Re: Australian Museum – Alterations and additions (SSD 9452) Notice of Exhibition

I refer to your letter dated 22 October 2018 inviting comments on the above State Significant Development for alterations and additions at the Australian Museum located at 1 William Street, Sydney, in the City of Sydney local government area. The subject site is listed on the State Heritage Register as the Australian Museum (SHR 00805) and is located in the vicinity of various other SHR items listed on the State Heritage Register.

1 Elevation 01
1:100

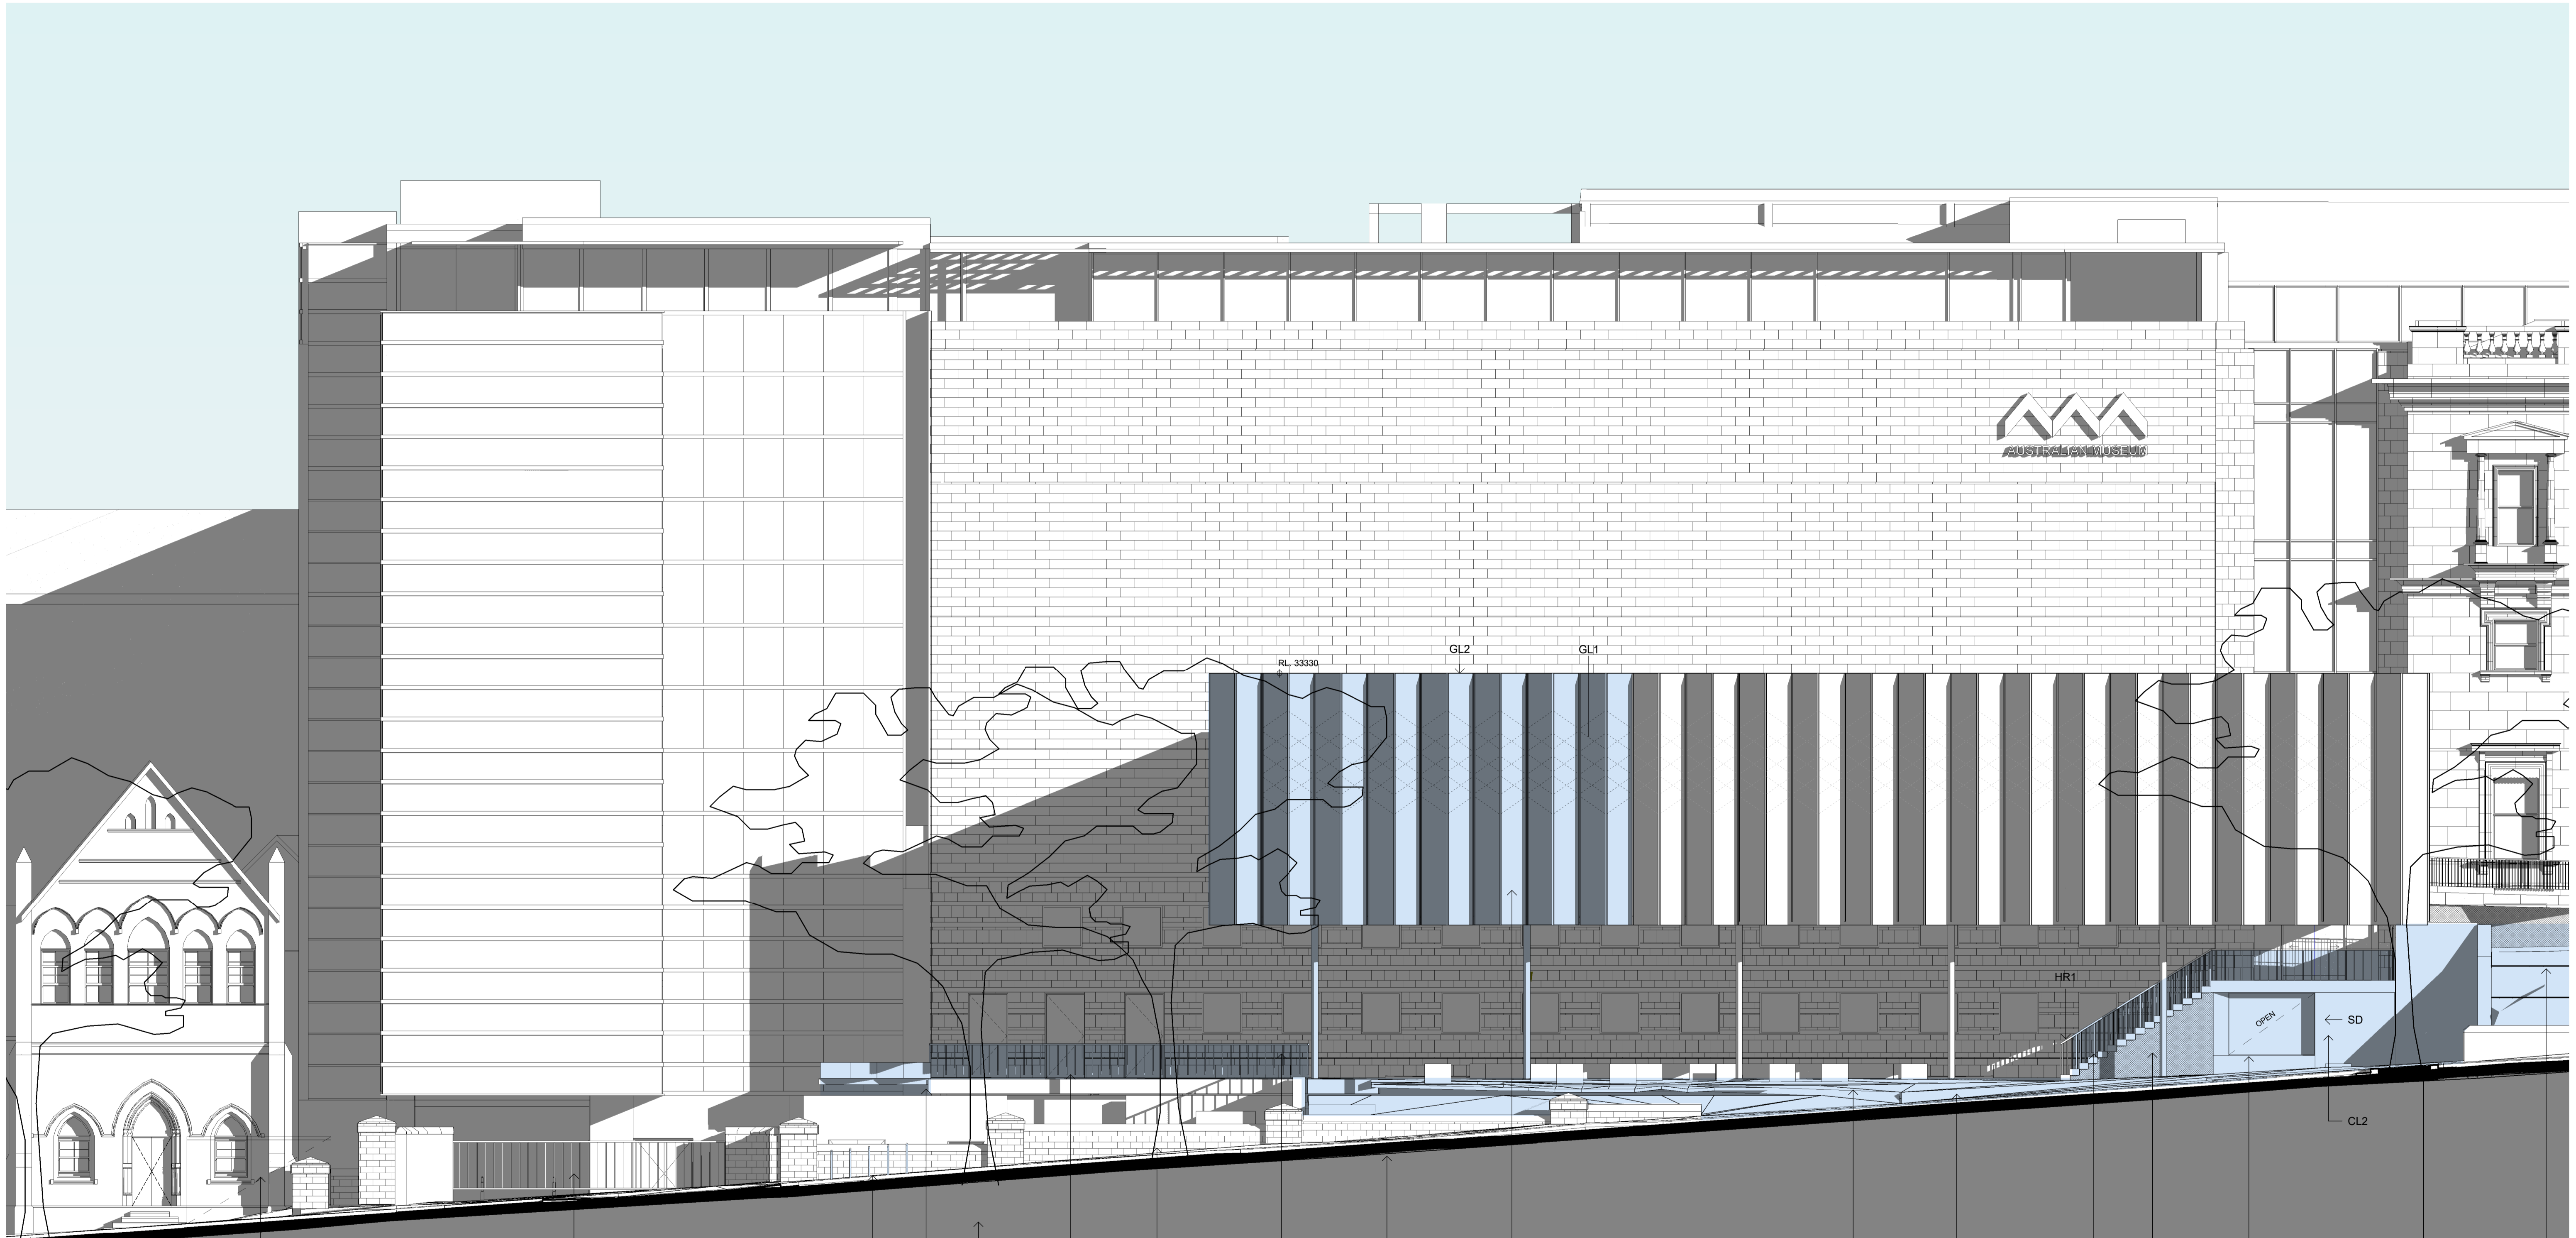
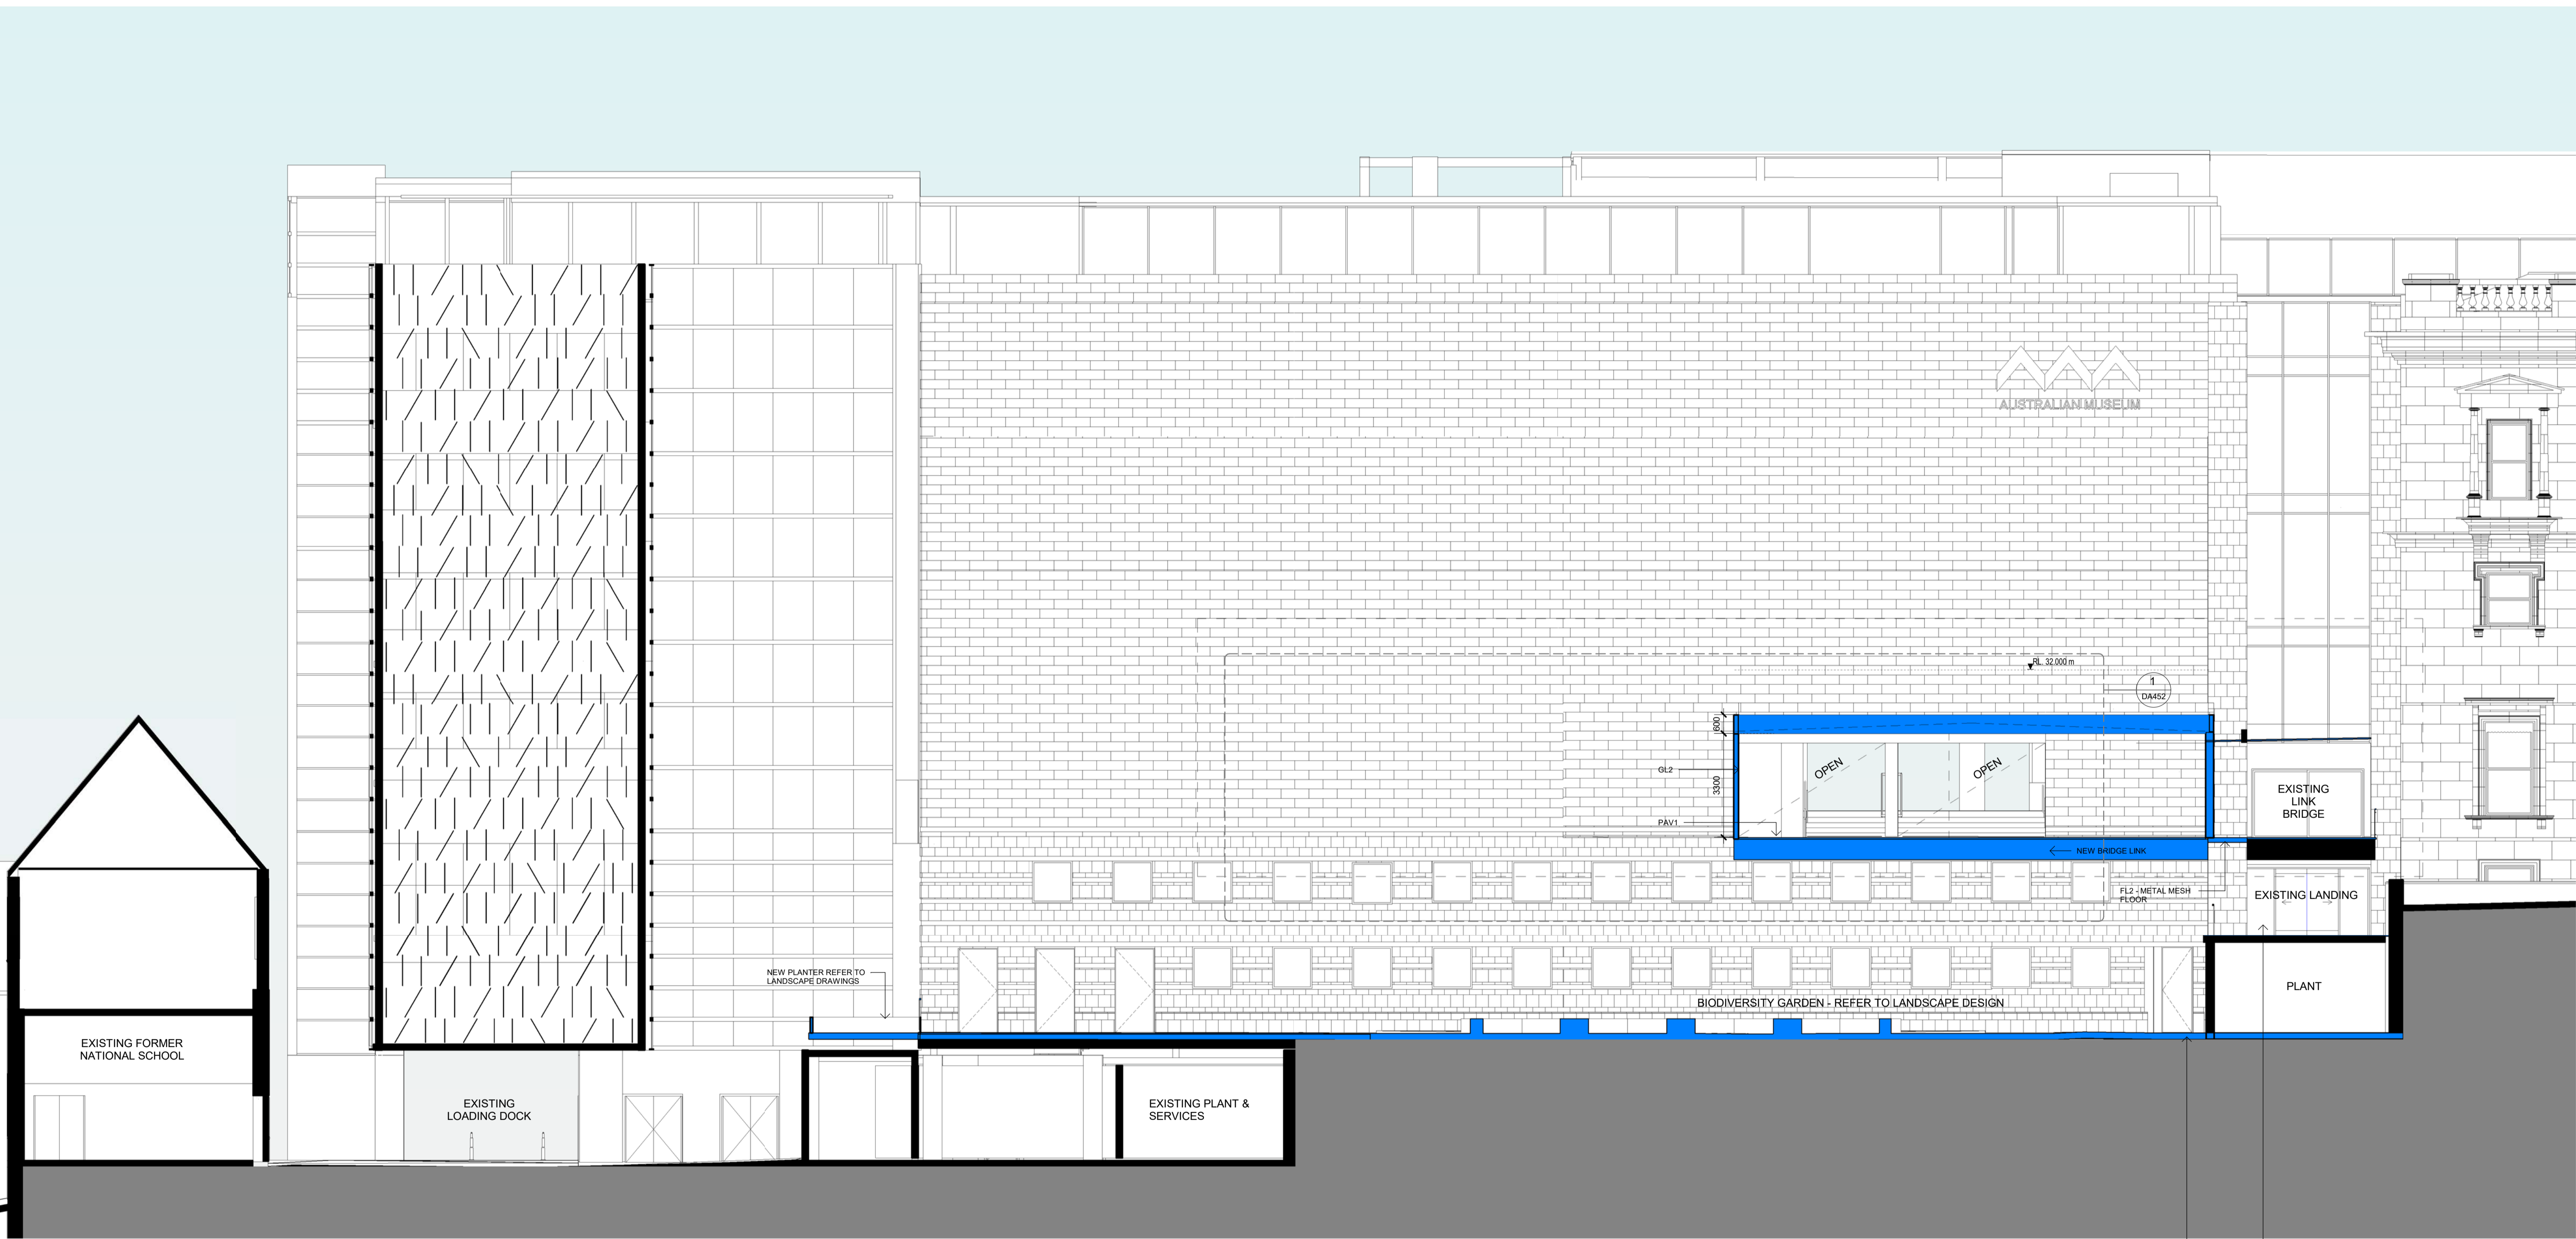
- Consideration should be given, and a methodology prepared to re-use the external stairs of 'medium' significance located north of the Parkes Farmer wing in the construction of the new stair configuration (re-oriented from an east-west to a north-south axis).

- A detailed schedule of materials and finishes should be prepared for the proposed extension to Chrystal Hall to demonstrate its consistence with the existing structure and ensure Crystal Hall reads as a single contemporary element on the Parkes Farmer wing north façade.
